06/05/2021

**Wagga Wagga Hospital Redevelopment - Stage 3 – Modification 5 (SSD-9033-Mod-5)
Request for additional information**

ARCHITECTURAL SERVICES
SITE PLAN - PROPOSED

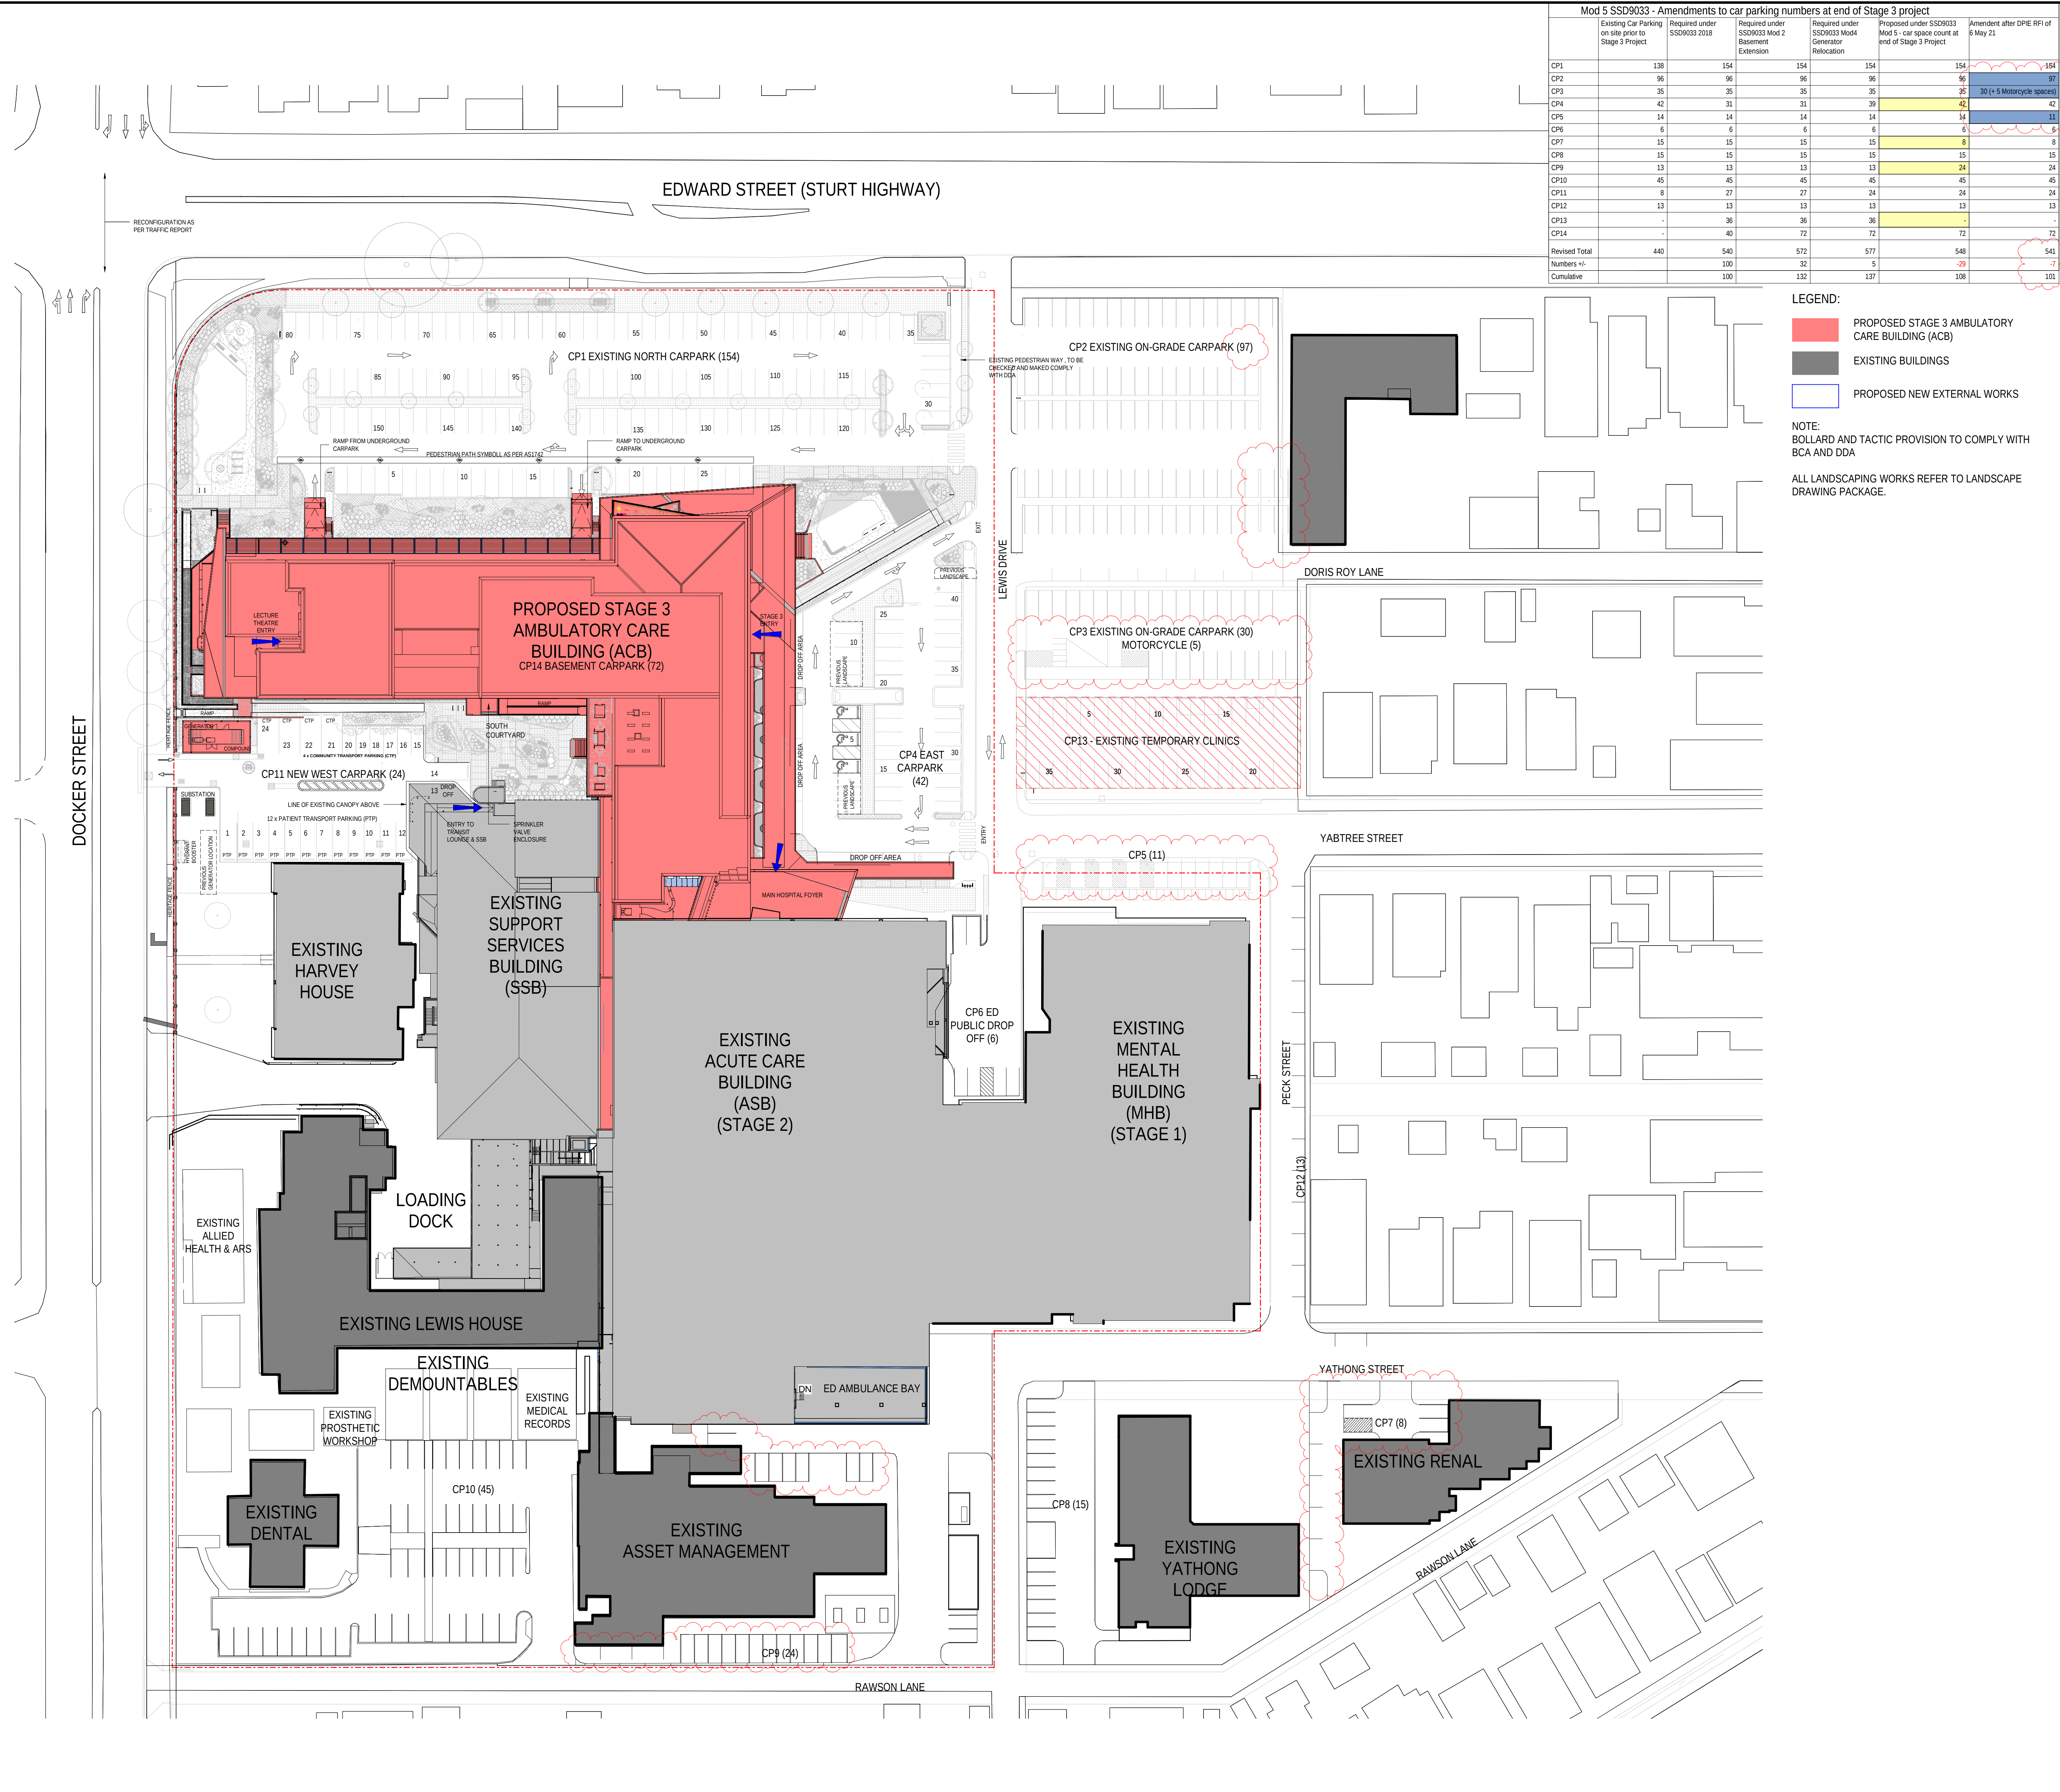
In order to allow assessment of the modification to progress, the Department requires additional information regarding parking supply across the Wagga Wagga Base Hospital campus. The total figure of 548 car spaces provided across the hospital campus does not appear to have been met when comparing aerial photography of the site to the amended site plan submitted with the modification application. In this regard, further clarification is sought on the following points:

- Table 3 in the modification report identifies 14 car spaces available within Carpark 5, however it appears from aerial photography of the site that only 11 spaces have been provided.
- the modification proposes to include 24 spaces located in Carpark 9, but it is unclear where these will be located from the amended site plan and aerial photography of the site.
- the modification proposes to include eight car spaces located in Carpark 7, but it is unclear where these will be provided. The amended site plan is to be updated to show the stated eight available spaces.
- the current layout of Carpark 3 is to be shown on the amended site plan (including the seven available parallel spaces on Doris Roy Lane, motorcycle parking and yellow hatched areas within CP3 where car parking is no longer available).
